## ARBORIST RESPONSE TO CITY REVIEW COMMENTS

REFERENCE: Arborist Response to City Review Comments RE: SUB22-009 (Cui Preliminary Short Subdivision)

SITE ADDRESS: 4833 90<sup>th</sup> Ave SE, Mercer Island, WA

DATE: 1/7/2024

Tree Planting Schedule

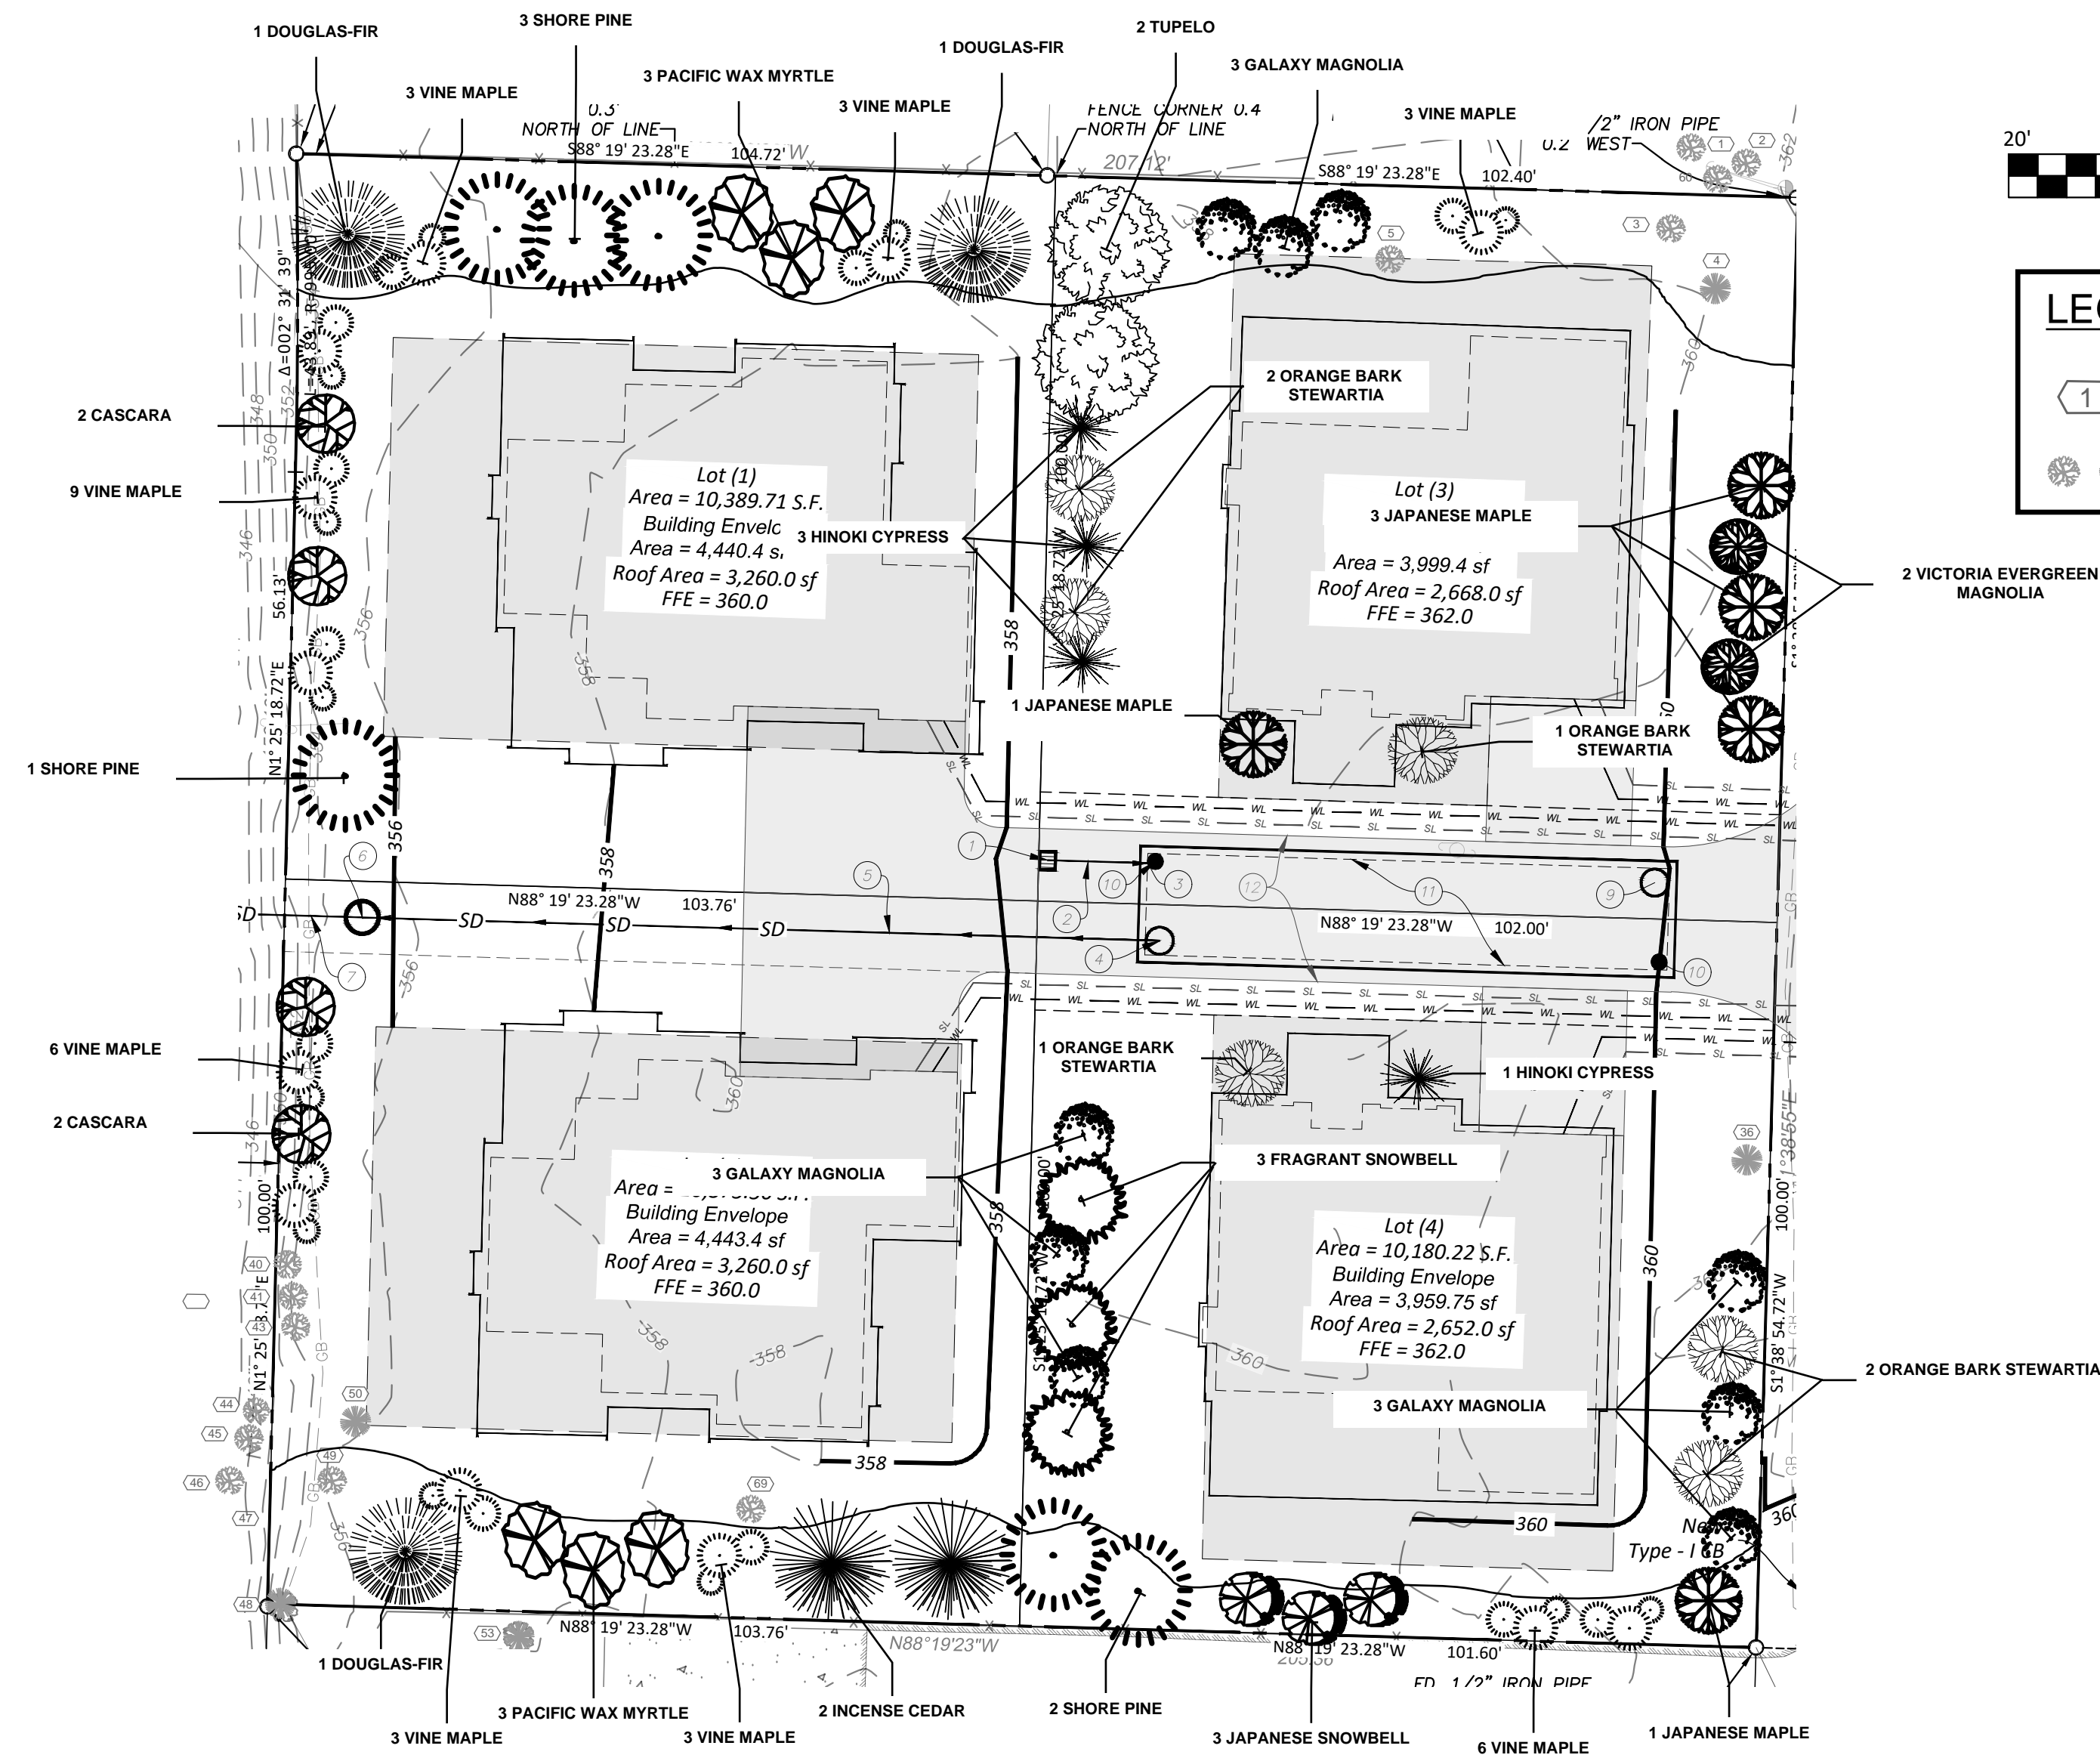
**3. Trees 7, 57, 61, 62, 65 are listed on the tree inventory worksheet as large regulated trees but are non-regulated since they are below 10 inches in diameter and do not become exceptional at that size. This will impact your percentage of trees to be retained. These trees are not required to be replaced since they are non-regulated.**

Arborist response: These five trees have been removed from the tree table and sheet TR-01. With these 5 trees removed, overall tree retention for this project is now at 32.7-percent. See the provided updated Tree Calculation Worksheet.
